From: Catchment_Management [REDACTED]
Sent: 15 May 2019 14:30
To: Simon Davis <Simon.Davis@arun.gov.uk>
Subject: RE: AL/27/19/DOC - GTR DENMANS LANE FONTWELL

Applicant:	Global Technologies Racing
Planning Application Reference:	AL/27/19/DOC
Proposal:	Approval of details reserved by condition imposed under ref AL/45/18/PL relating to Condition No 3 surface water drainage and Condition No 8 piling.
Location:	Global Technologies Racing Ltd Denmans Lane Fontwell BN18 0SU
Date:	15 May 2019

Portsmouth Water have reviewed the request to discharge condition 3 (surface water drainage) and condition 8 (Piling) and have the following comments.

FOUNDATION NOTES :-

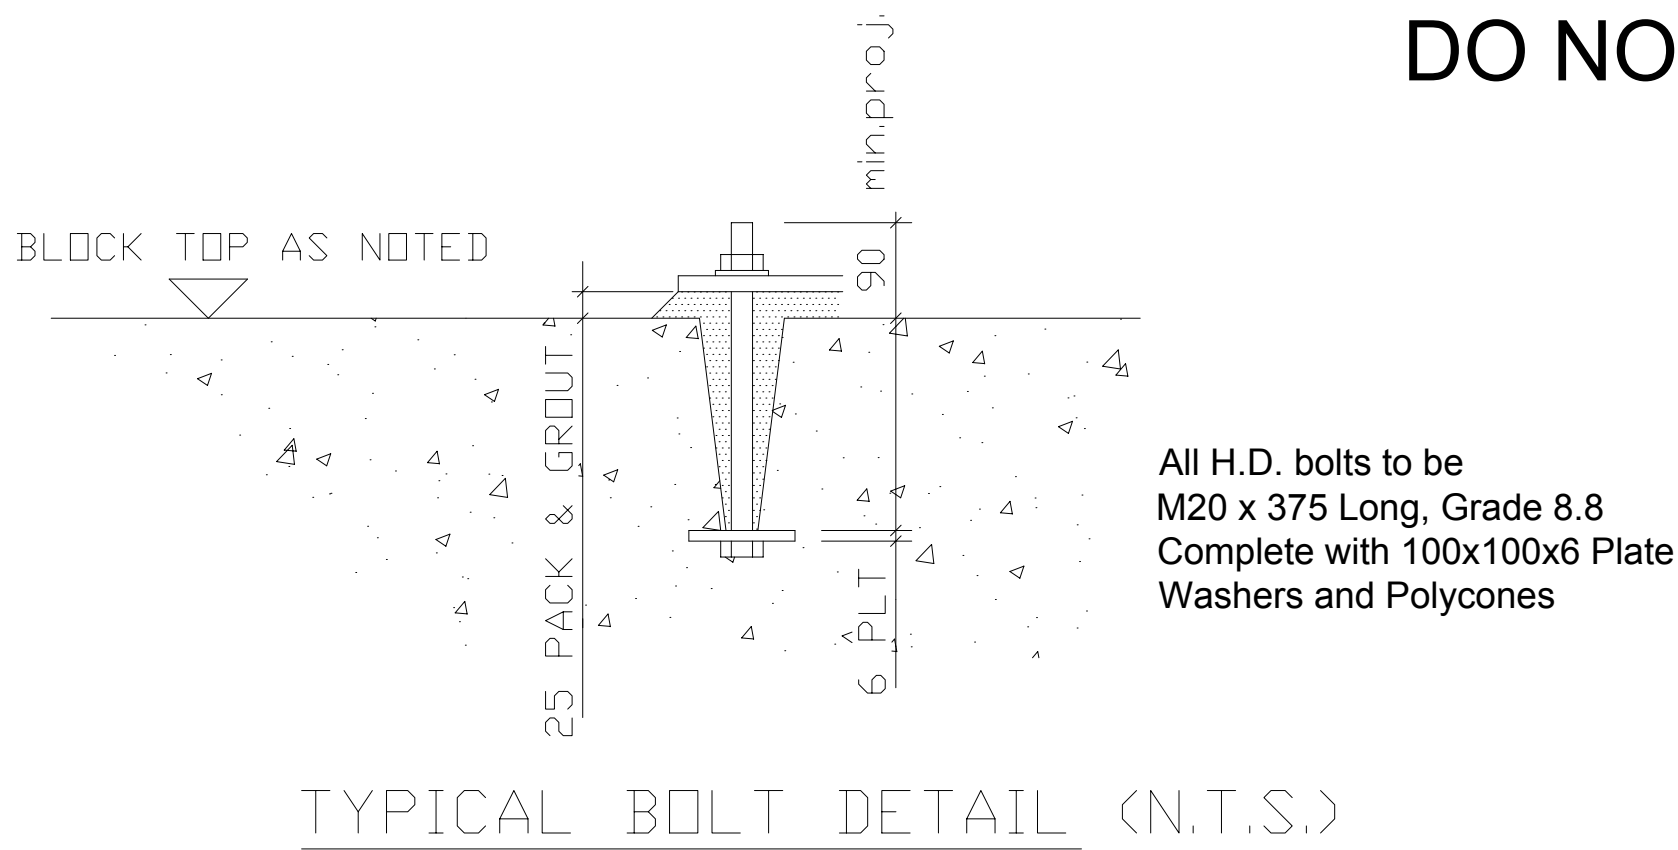
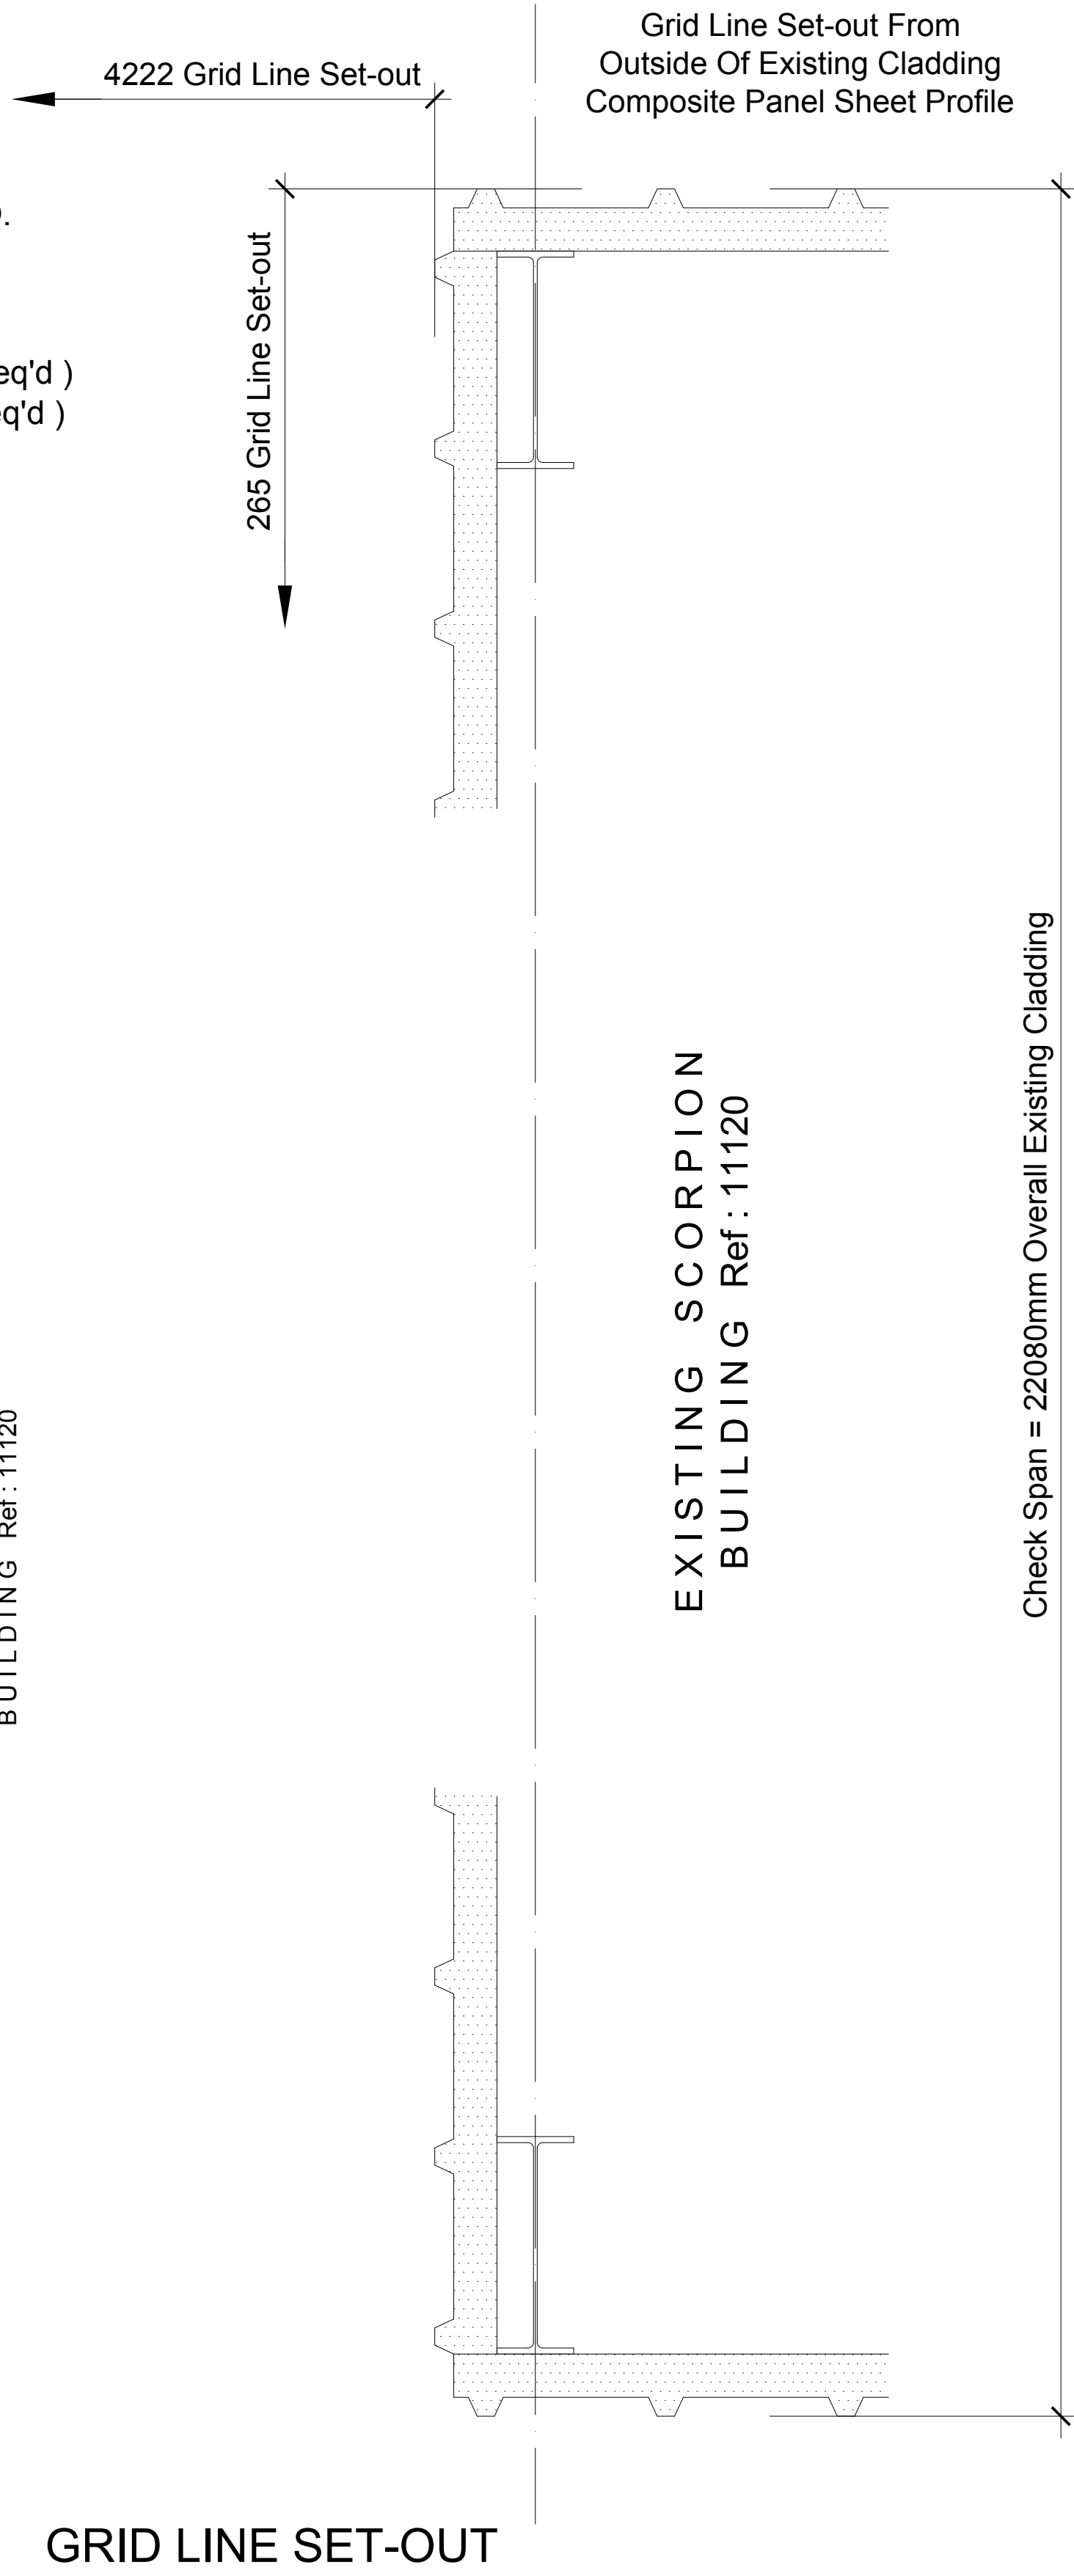
In regards to condition 8 we have no objections to this foundation solution as the depth is less than the depth of clays underlying the site and therefore there is not a risk of foundations into the chalk. We would therefore have no concerns with the discharge of Condition 8 relating to this application.

The foundation solution for the site will be concrete blocks to a maximum depth of 1.75m with no piling planned. Clays underlie site to a depth >8m thus greater than the depth of the foundation solution. Therefore, Portsmouth Water would have no concerns regarding the proposed foundation solution and would have no objections to the discharge of this condition.
